**Consultation Response from KC,
Trees**

2024/92075 2 A, East Bath Street, Batley, WF17 5NP

Demolition of existing dwelling and erection of two detached dwellings

Date Responded: 05/06/2025

**DRG:**  
PROPOSED SITE PLAN

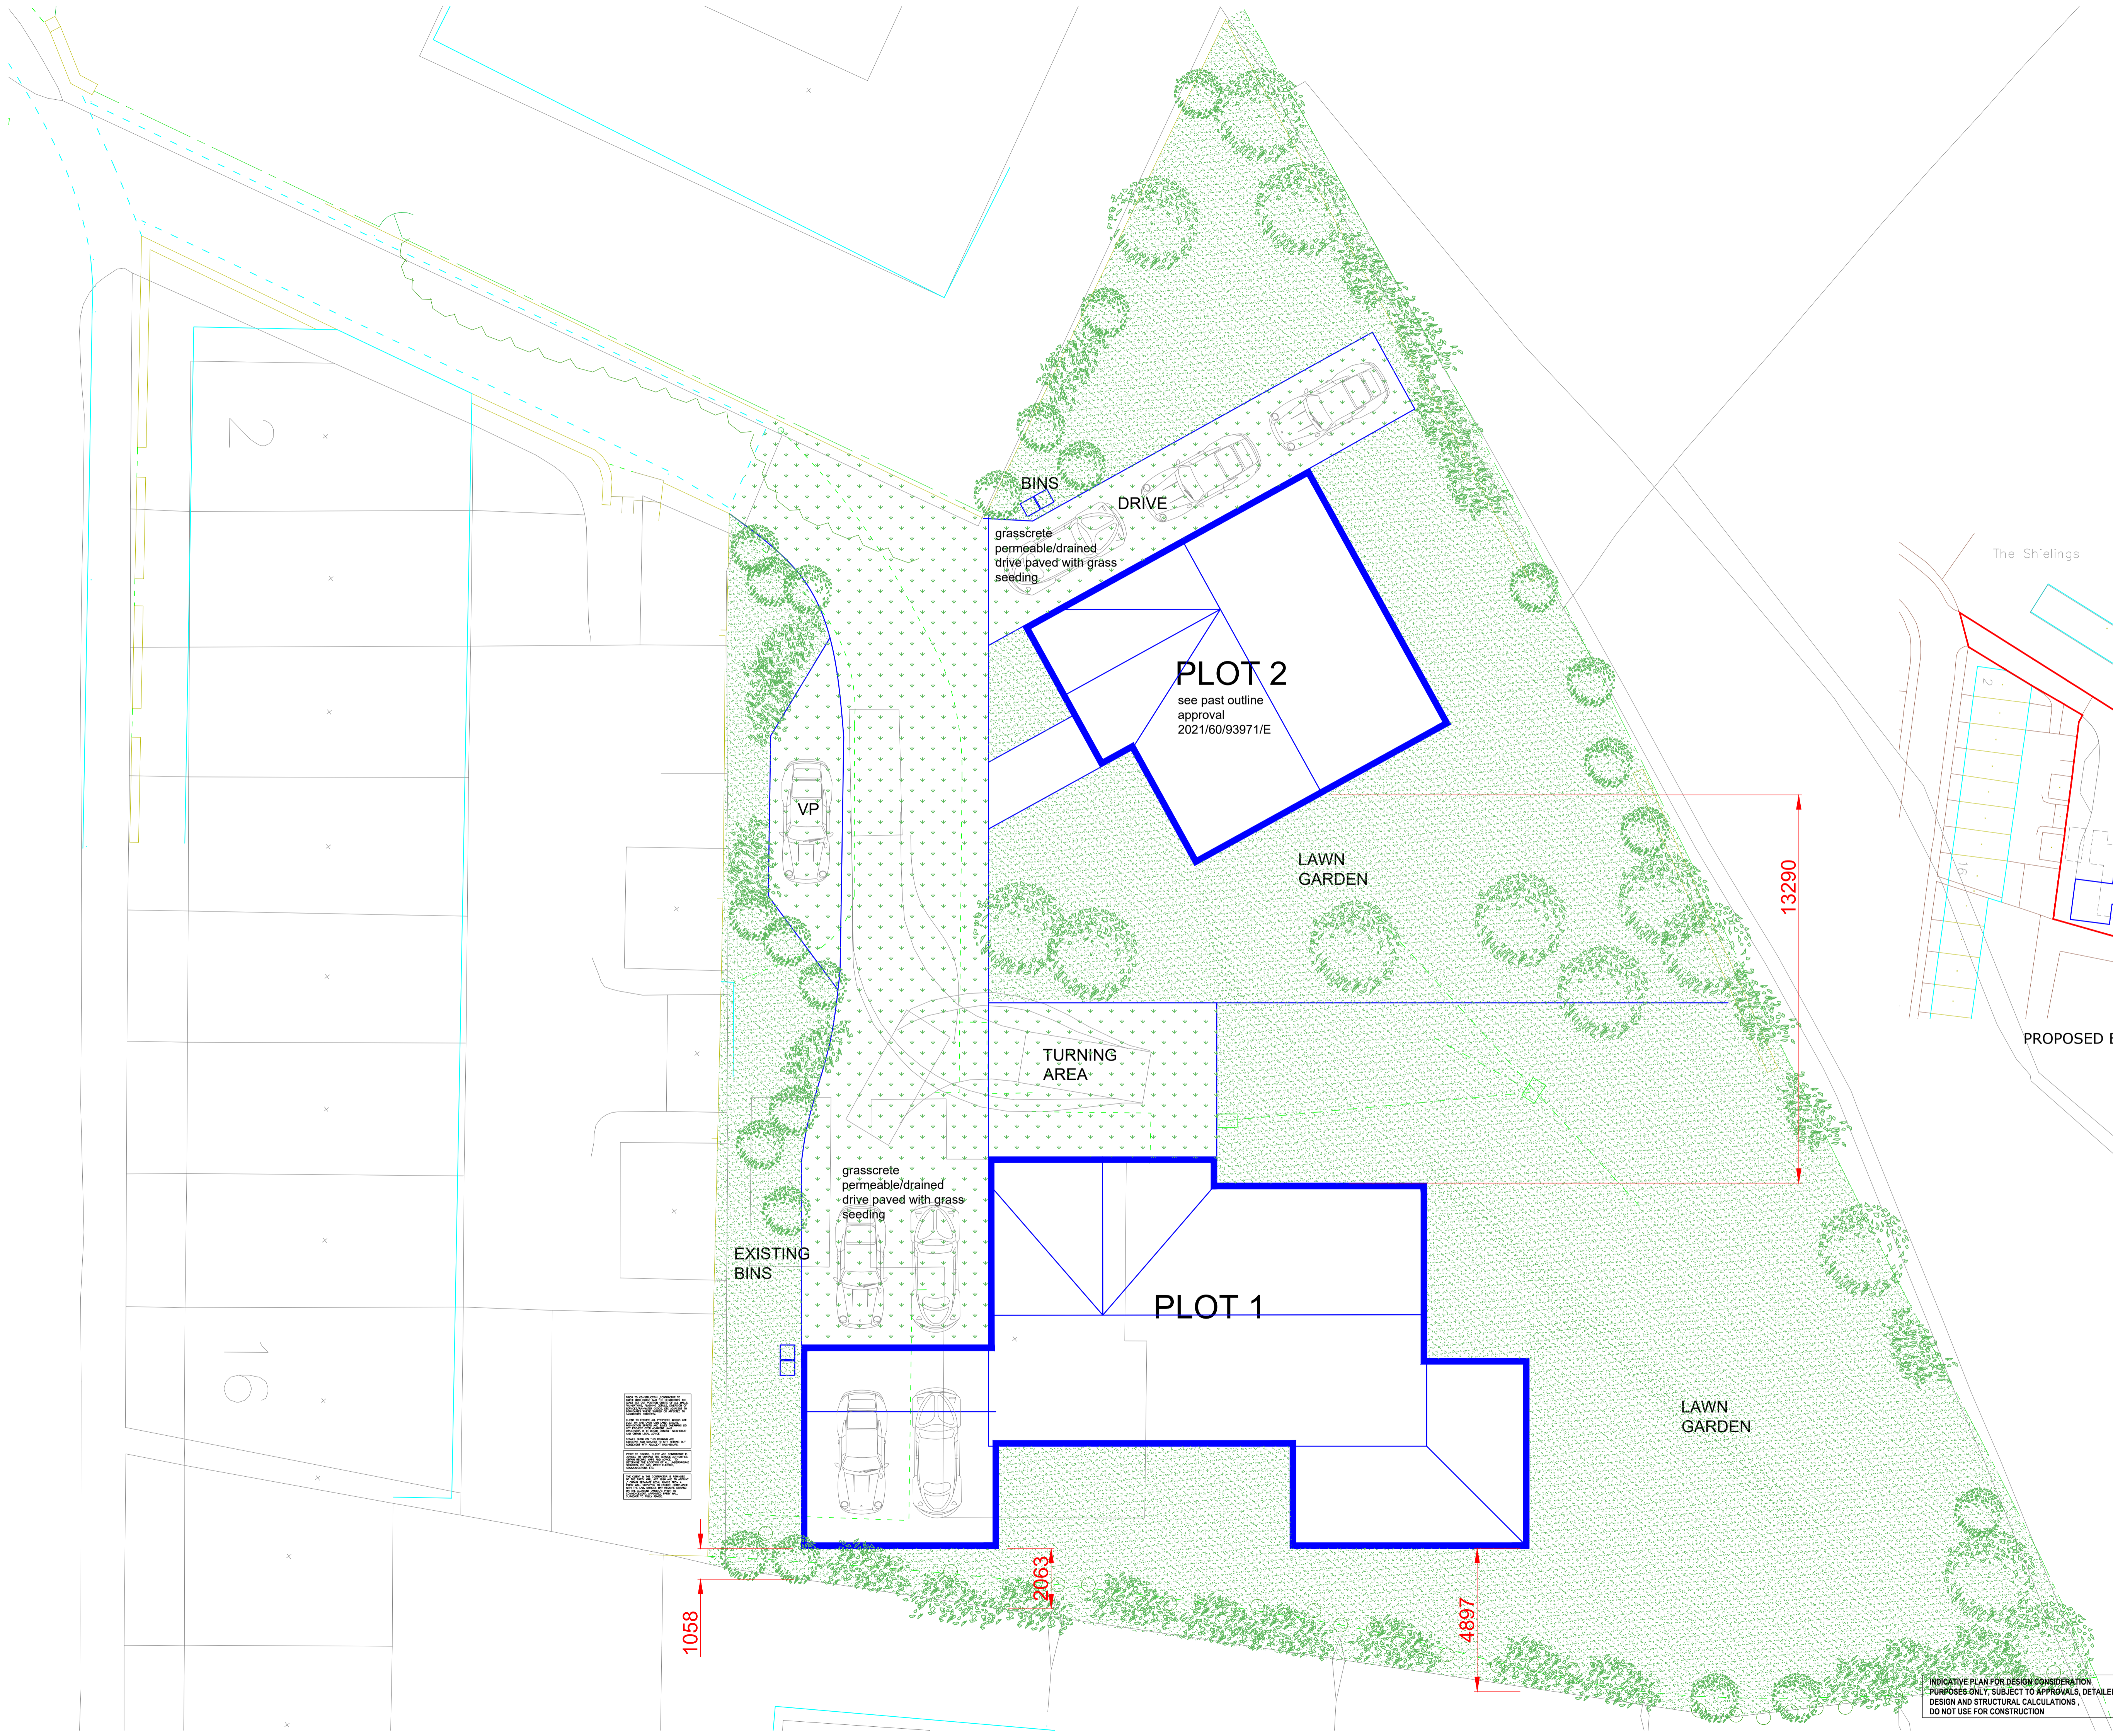
The new layout would require the removal part of H8 to accommodate the construction of Plot 1. This will cause a loss of the screening into the site offered by the existing Leyland Cypress hedge (currently up to 16m tall) but is acceptable from an arboricultural perspective.

The construction of Plot 2 in this amended location would slightly encroach into the RPA of T3. Again, this would be acceptable as the encroachment would be minor and the ground protection stipulated within the AMS would prevent the construction from causing any further damage e.g. compaction to the soil environment within the RPA.

Additionally, the western edge of the canopy of T3 would conflict with the southeast corner of the proposed house if constructed in this updated location. The AMS should be amended to include the access facilitation pruning required to create working space between plot 2 and the western edge of the canopy of T3. This pruning work should be carried out prior to the commencement of construction to prevent accidental damage to the tree.

Subject to the amendment of the AMS, to include the access facilitation pruning to T3 as described above, there are no objections to the proposals from an arboricultural perspective.
